Hornsea Project Four

Applicant's comments on other submissions
received at Deadline 6

Deadline 7, Date: 10 August 2022

Document Reference: G7.2

Order Limits Interaction and Disposal Area

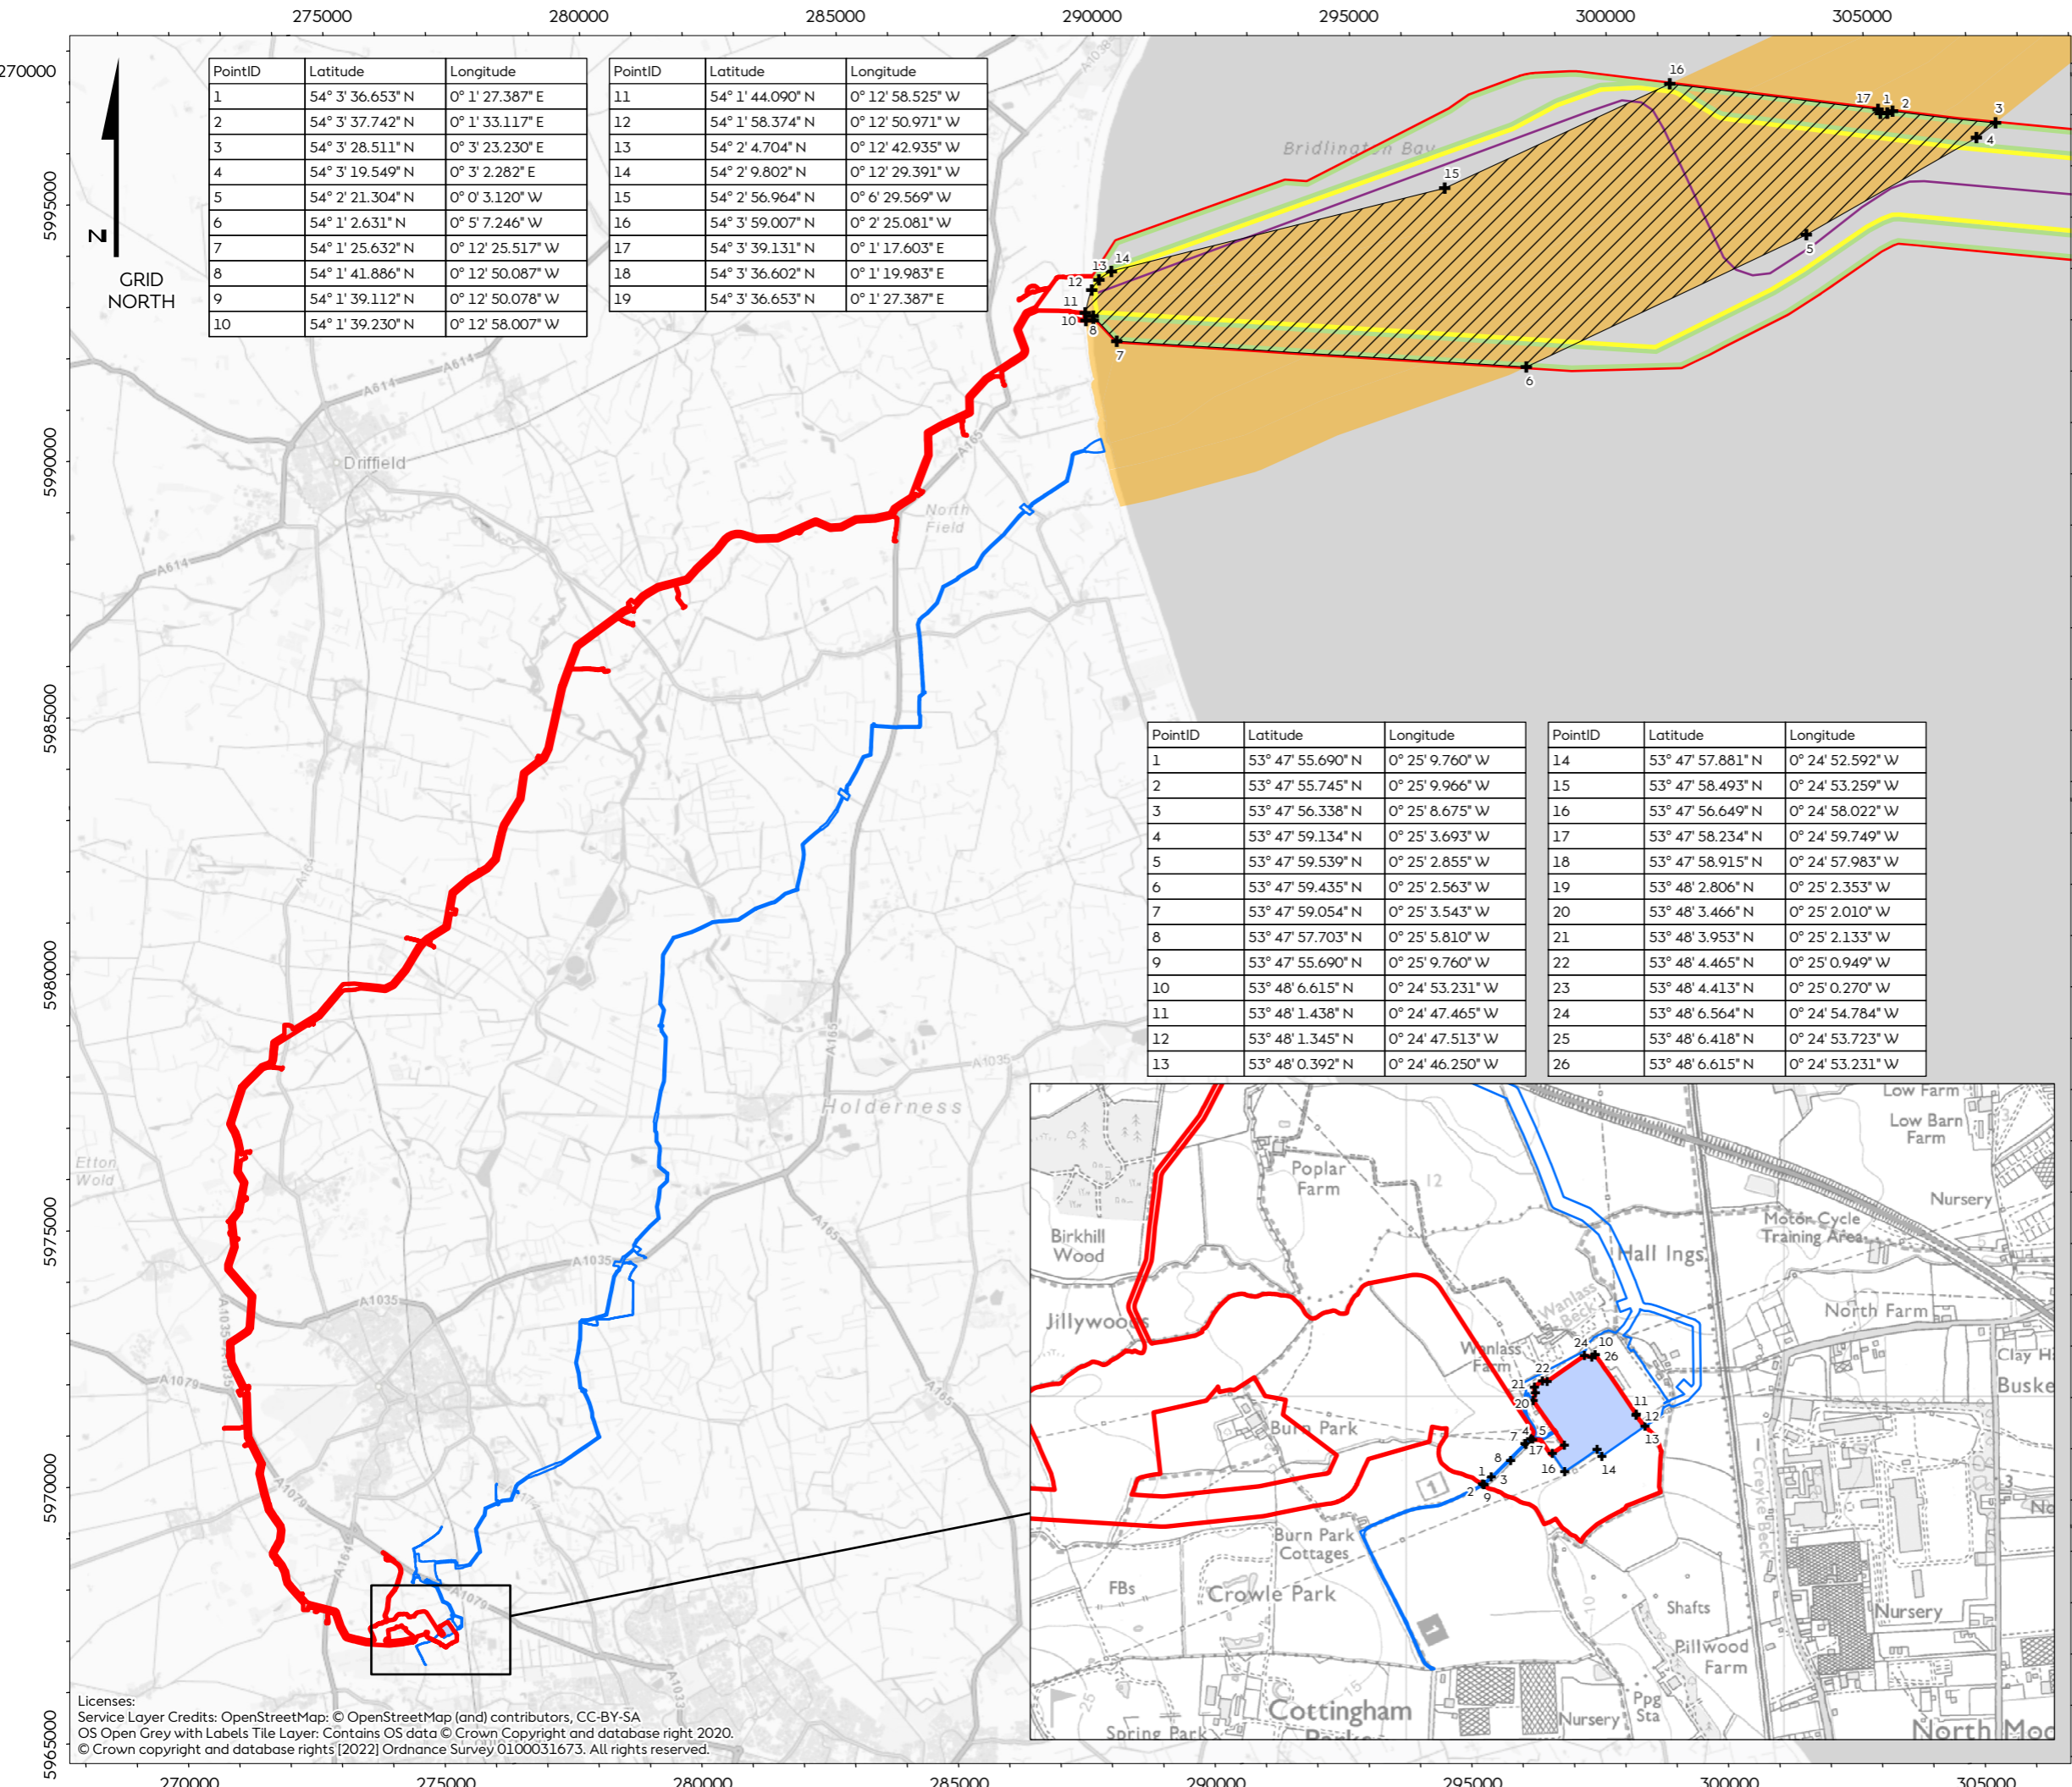
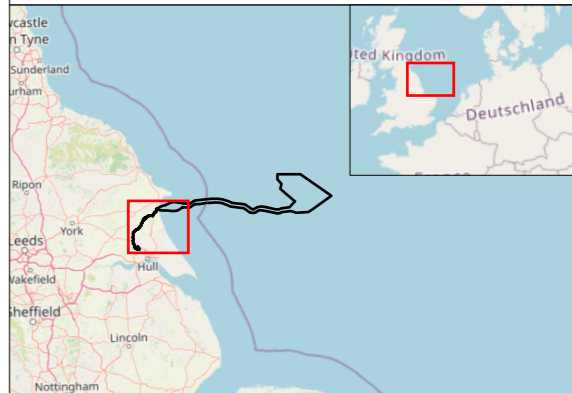
1.4.6	The MMO confirm that the Doggerbank A and B Export Cable Corridor (ECC) is not an open disposal site, and as such the Hornsea Project Four will be able to have its ECC designated for disposal. The issue of overlapping disposal sites is not applicable. The MMO supports the re-implementation of this area as a disposal site to allow for the retention of sediment within the Flamborough Front System.	The Applicant welcomes the MMO's confirmation that the Dogger Bank A & B Export Cable Corridor (ECC) is not a designated disposal site and the previous issue of potentially overlapping disposal sites is no longer applicable. The Applicant had pre-empted this and reimplemented the reinstatement of the entire Hornsea Four ECC as a single disposal area by way of amendments included in the Deadline 5a draft DCO (REP5a-002).
